A303 Sparkford to Ilchester Dualling Scheme TR010036

8.10 Draft Statement of Common Ground with Queen Camel, West Camel and Sparkford Parish Councils

STATEMENT OF COMMON GROUND

Version	Date	Status of Version
Rev 1	January 2019	Draft for Examination Issue

INSET H: EXISTING ROADS AND PROW TO BE STOPPED UP

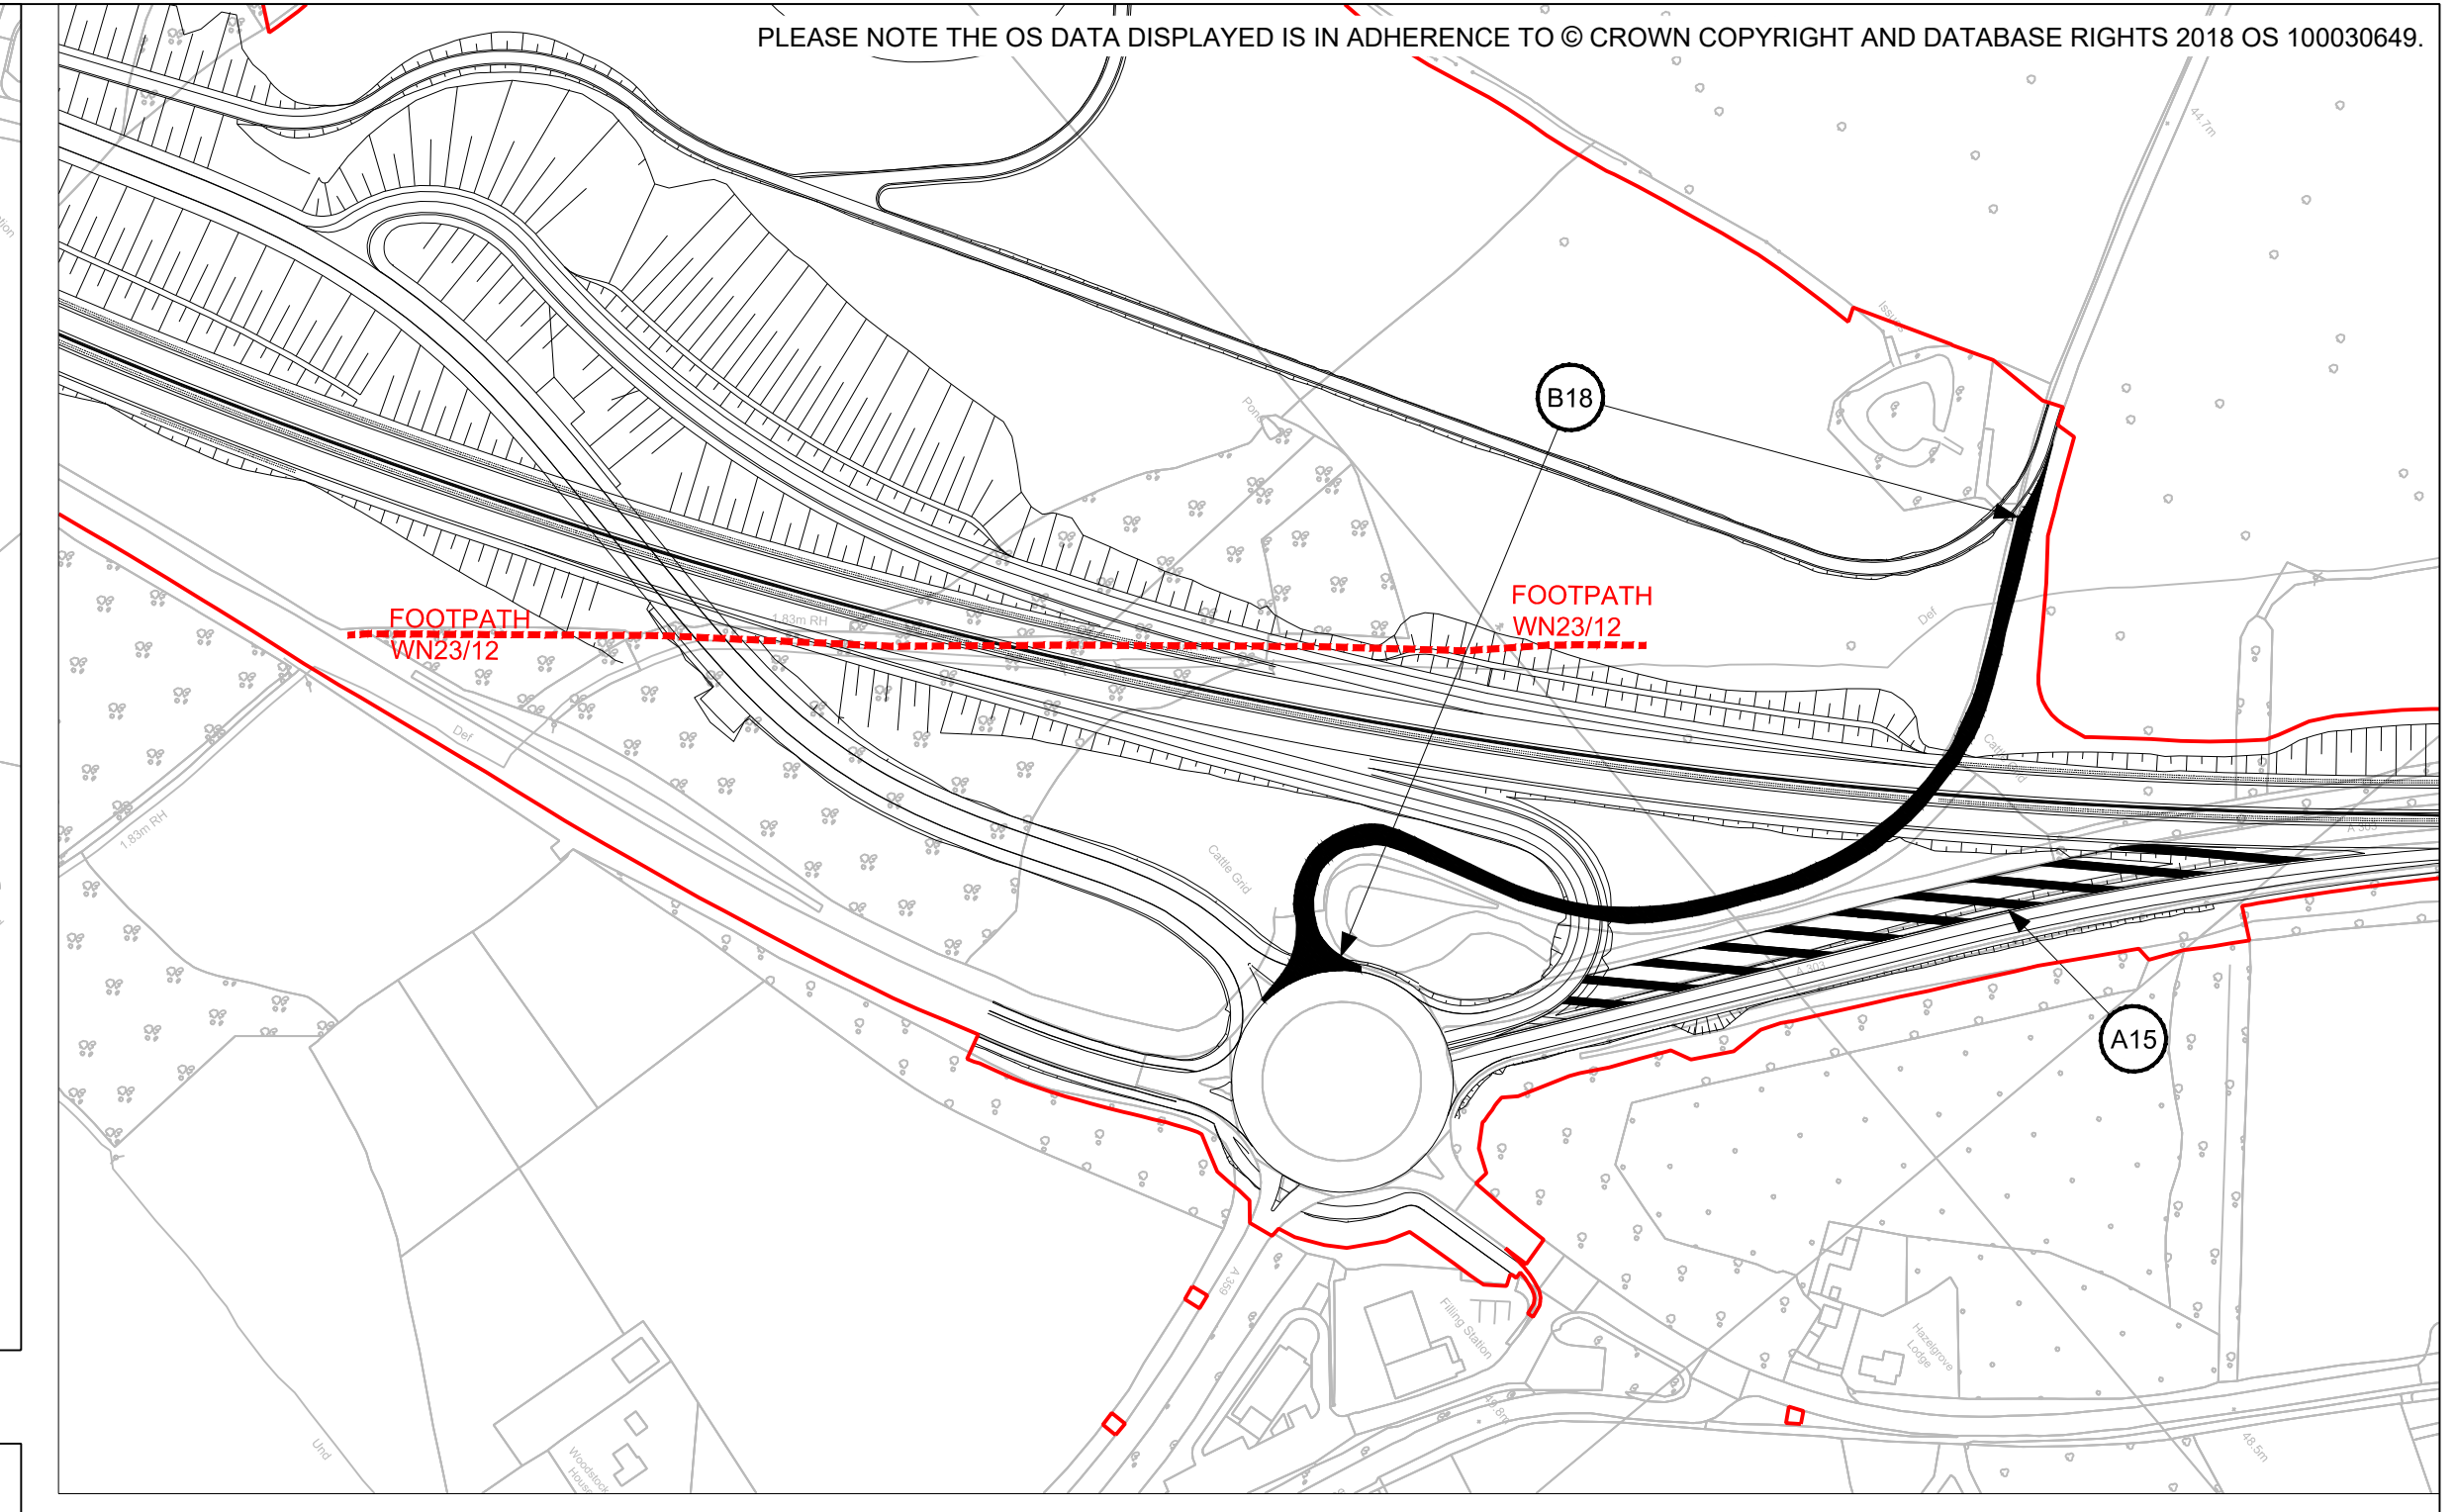
Public Rights of Way	The public rights of way will also be affected and protracted by the poor design of the Hazlegrove junction with walkers and horse riders forced to walk or ride along access roads to join rights of way within Hazlegrove park. Sparkford PC are still concerned with the poor design of the slip roads and that the under bridge will have no lighting during the periods of darkness.	A dedicated non-motorised user (NMU) route has been provided alongside the local road carriageway at the underbridge. This route will be segregated from motor traffic. It has been provided on the southern verge of the local road deliberately in order to avoid crossings of the eastbound merging slip road and the Hazlegrove School access.	UNDER DISCUSSION
